## Planning Services Sign Permit Review Form

Date of Submittal	Application Number	Applicant	Landowner
8/07/2020	SIGN2008-0002	Allen Industries	Boddie Noell Enterprises

Contact Person	Contact Number
Heather English	(336) 799-4670
Sign Location	PIN Number
2471 NC 87 S. Cameron	9575-95-4454.000

FRONT ELEVATION
Scale: 1/8" = 1'-0"

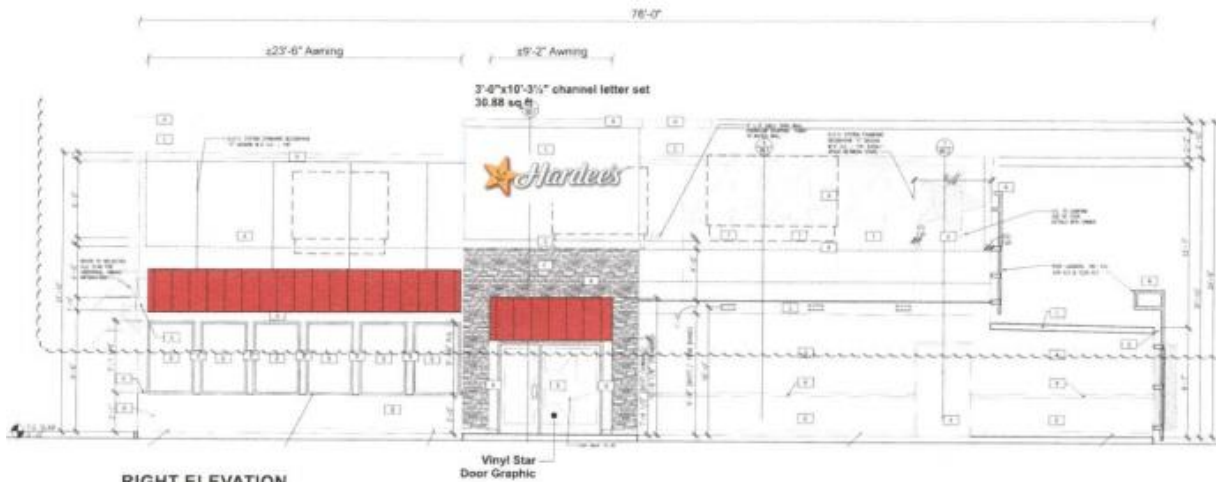
Comments	<ol style="list-style-type: none"> <li>1. Ground sign exceeds maximum height permitted. Please reduce height of ground sign by 2".</li> <li>2. Please label distance of ground sign to the front and side property lines. 20' from each property line is required.</li> <li>3. Please provide size of the vinyl window graphics in square feet.</li> </ol>
----------	--
